# Cottam Solar Project

## Statement of Common Ground with Scunthorpe & Gainsborough Water Management Board

Document reference: EX5/C8.3.15\_A

### Statement of Common Ground Scunthorpe & Gainsborough Water Management Board

### Figure 8.16.2: Landscape and Ecology Mitigation and Enhancement Plan – Cottam 1 North (Sheet 2) Revision A

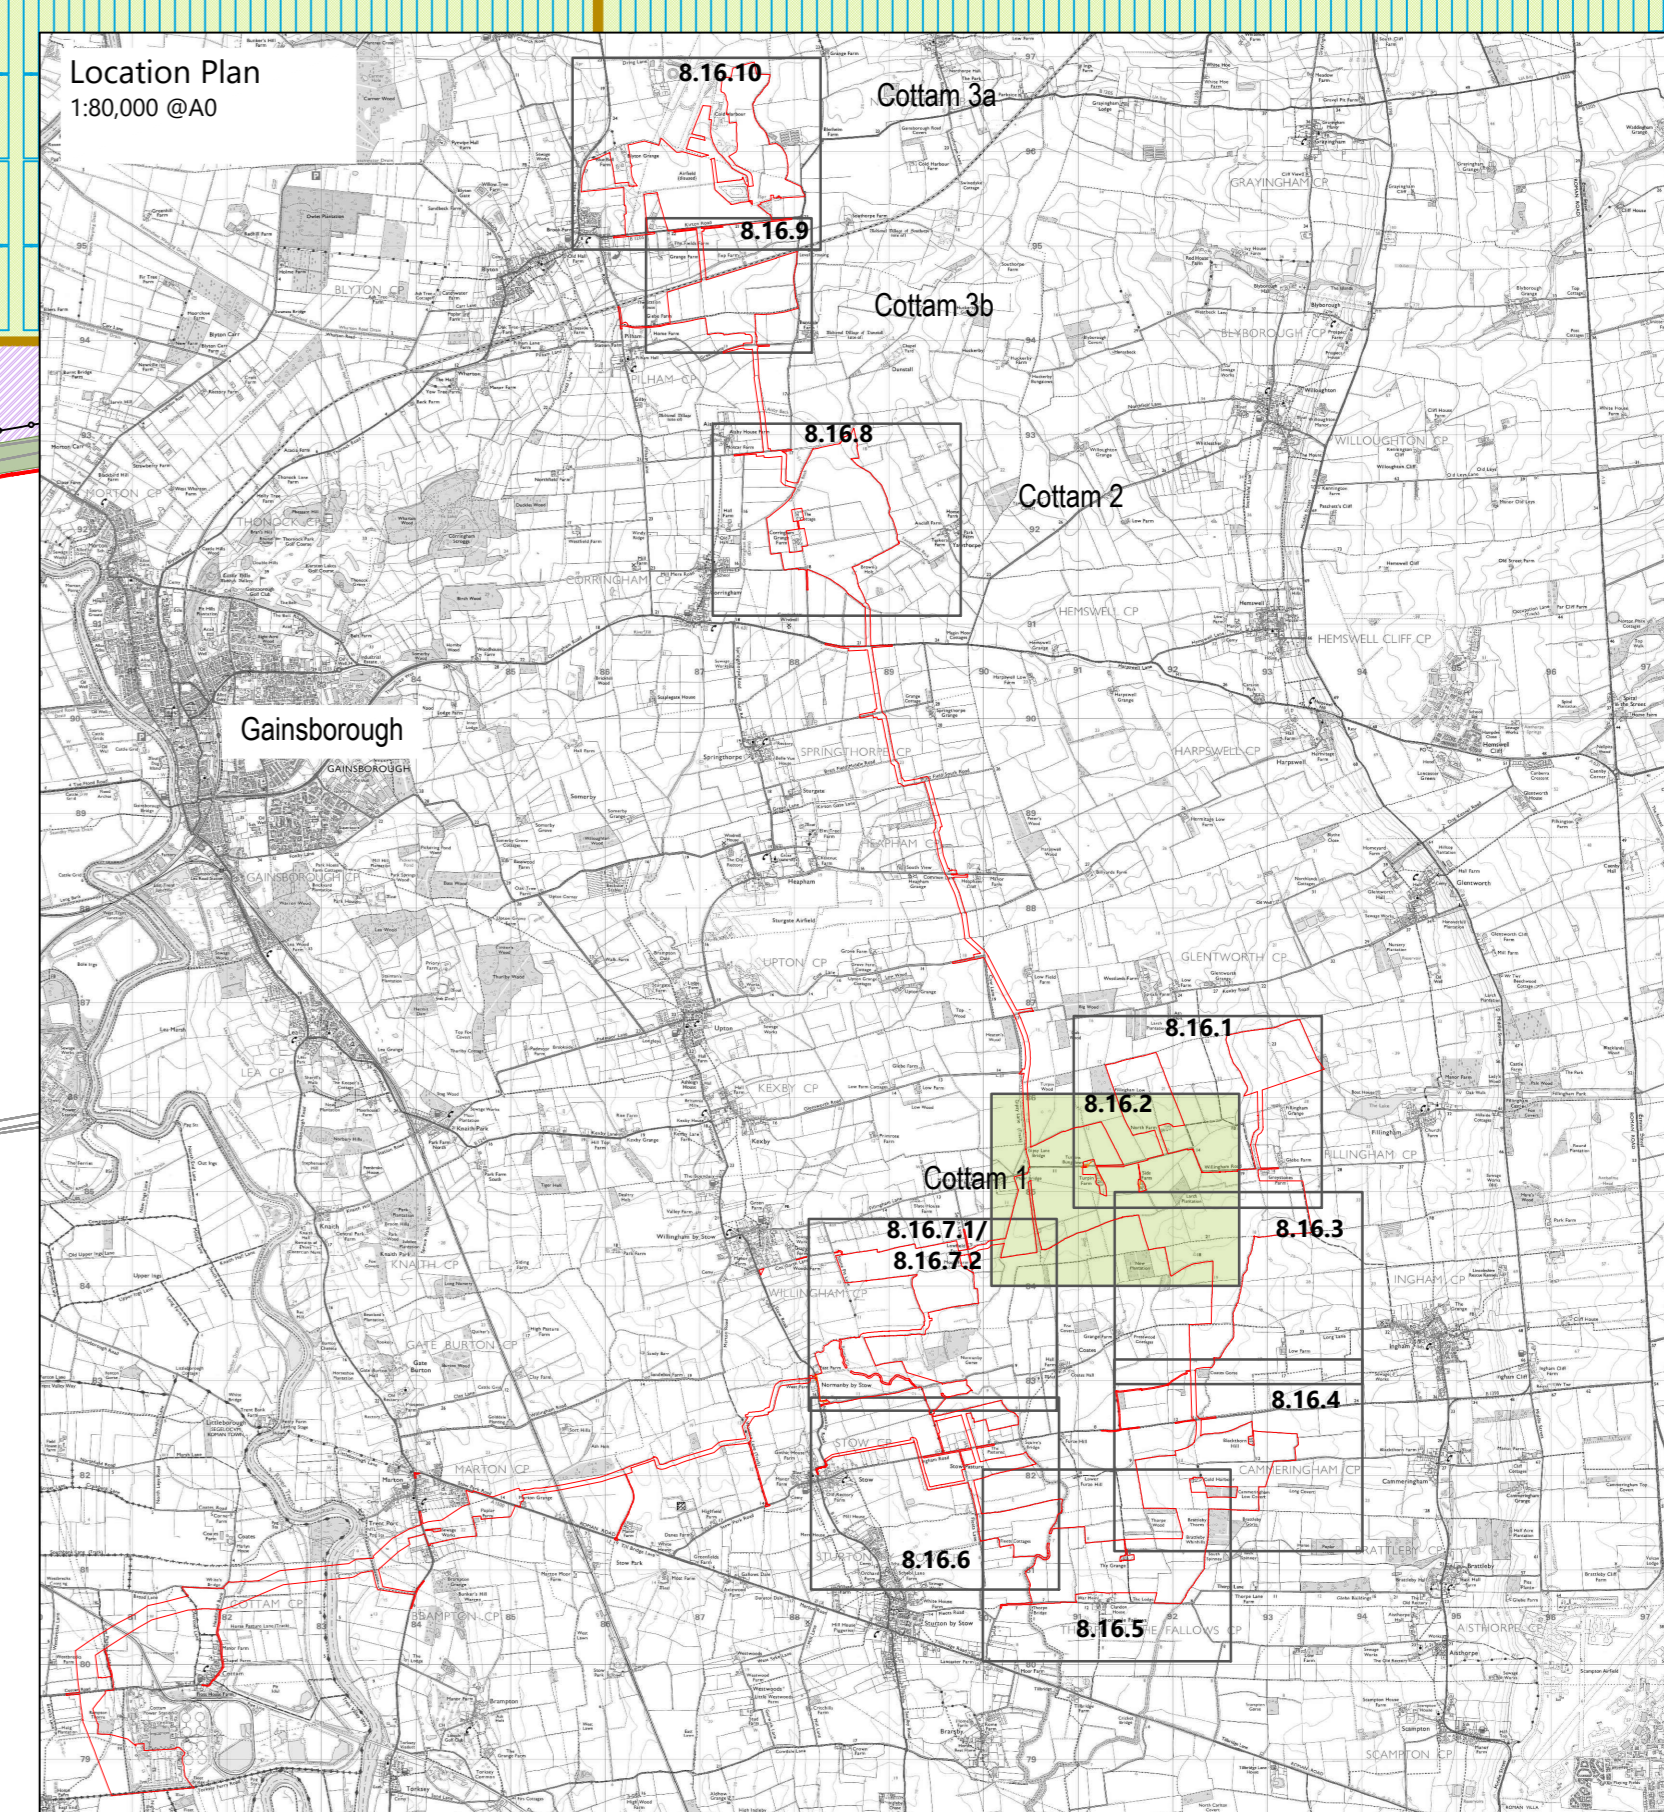
works" within 9m of any of the IDB's drains/watercourses.  Please also see the response to HY-03 below.
<u>Hydrology</u> <u>HY-02</u>	Identification of Watercourses	<p><i>"Figure 8.16.2: IDB watercourses not clearly identified."</i></p> <p>S&amp;GWMB have identified assets which may be impacted by the proposed scheme.</p> <p><b><u>S&amp;GWMB maintained watercourses</u></b></p> <p><b><i>Work Plan 2 (P2981_LPR_ZZ_ON_DR_Z_0064)</i></b></p> <p>Work Package 6A may impact on the 9m easement on both sides of Aisby Beck</p> <p><b><i>Work Plan 3 (P2981_LPR_ZZ_ON_DR_Z_0064)</i></b></p> <p><i>Work Package 1B may impact on the 9m easement on Corringham Beck, Yawthorpe Beck and River Eau ordinary watercourse (upstream of main river).</i></p>	<p>These IDB watercourses and drains have been considered throughout the layouts with a 9m offset as has been possible and as shown on <b>Landscape and Ecology Mitigation and Enhancement Plans (Figures 8.16.1 to 8.16.10) [APP-305 to APP-315]</b>. The Applicant has discussed this matter with the IDB and both parties are in agreement that the scale of the Scheme makes it impossible to provide the full information regarding detailed design at this stage.</p> <p>The Applicant notes that the drawings are based on the currently available data and mapping and in some cases the 'top of bank' is not defined. It notes that further survey work will be required to establish the 'top of bank' which will in turn give the 9m offset and required clear working access. The IDB can provide a shape file to confirm the locations during the detailed design stage post DCO consent.</p> <p>The Applicant will then provide a specific plan to the IDB at the detailed design stage (post DCO consent) to give clear details of all 9m</p>
